**Our Case Number:** ACP-323575-25

**An  
Coimisiún  
Pleanála**

**Date:** 24 April 2026

**Re:** Proposed extension of port facilities to support Offshore Renewable Energy ('ORE') development and ancillary works at Port of Waterford, Belview, Co. Kilkenny. ([www.250berth.portofwaterford.com](http://www.250berth.portofwaterford.com))

PERMEABLE PAVING (PARTIAL INFILTRATION)

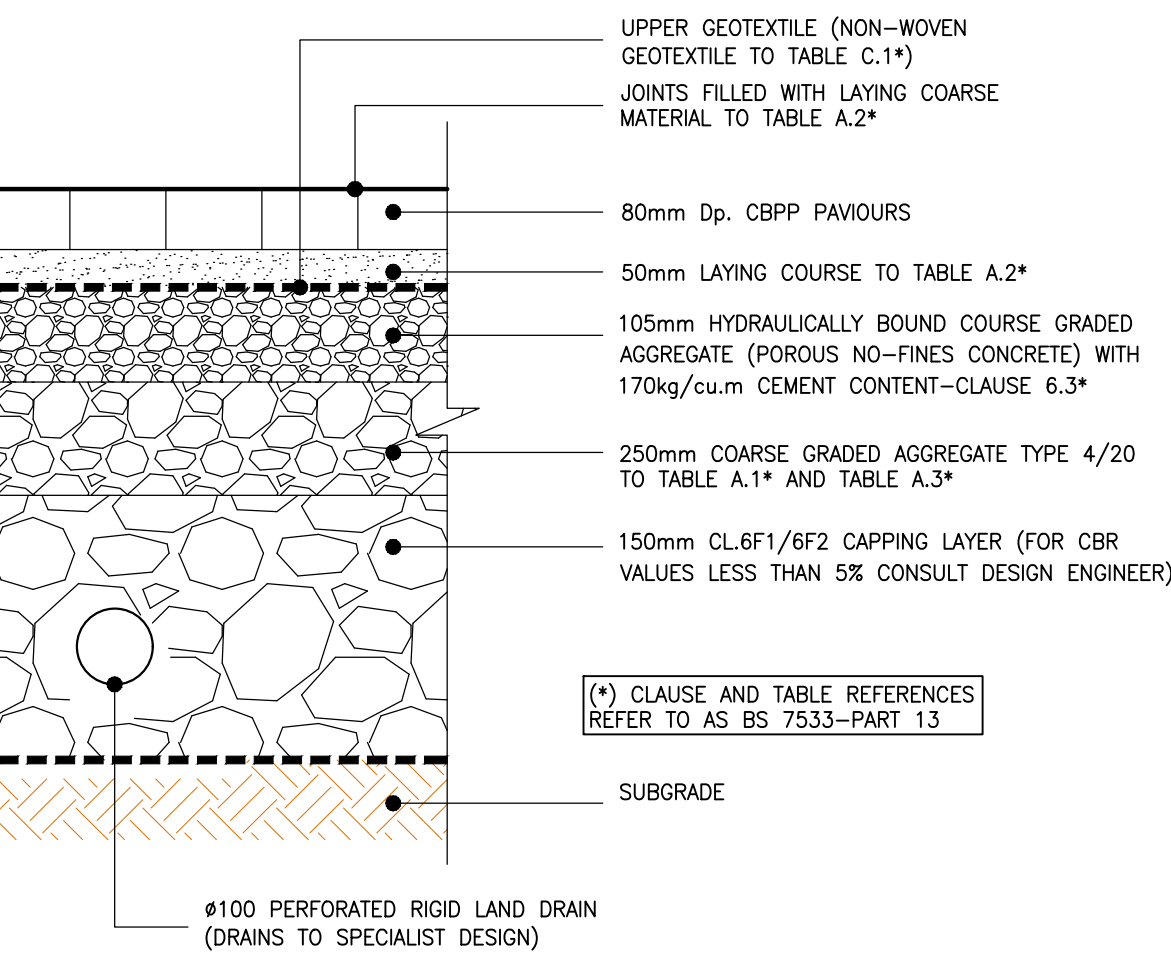
- (a) The proposal to provide permeable paving at the car park north of the railway line is noted, however, the Commission has concerns in relation to potential impacts on groundwater as there has been no assessment of pollutant load from parking areas (hydrocarbons, metals, sediments) and no justification provided for omitting treatment prior to infiltration nor a discussion of potential interaction with the Luffany Stream. The applicant is requested to provide further assessment of this issue that justifies the approach adopted or an alternative approach that ensures protection of ground and surface waters at this location.

- (b) Further to 8(a) above in the context of the submitted Water Framework Directive (WFD) Assessment submitted. The Commission considers that it is not appropriate to screen out the potential for impacts and interactions with the Waterford groundwater body on the basis that *"the site is located on the edge of the GWB and the majority of proposed works do not interact with groundwater"*. This statement indicates that some works do interact with groundwater, and the permeable ground proposed at the car parking area north of the railway line will allow direct connection to ground, it is also noted that a temporary construction

compound may be provided in this area. The applicant is requested to provide further justification which clearly demonstrates and clarifies either a break in the pathway between the proposed development and groundwater or alternatively carry out further assessment within a revised WFD assessment which provides suitable mitigation measures to ensure protection of groundwater from the proposed development during the construction and operational phases.
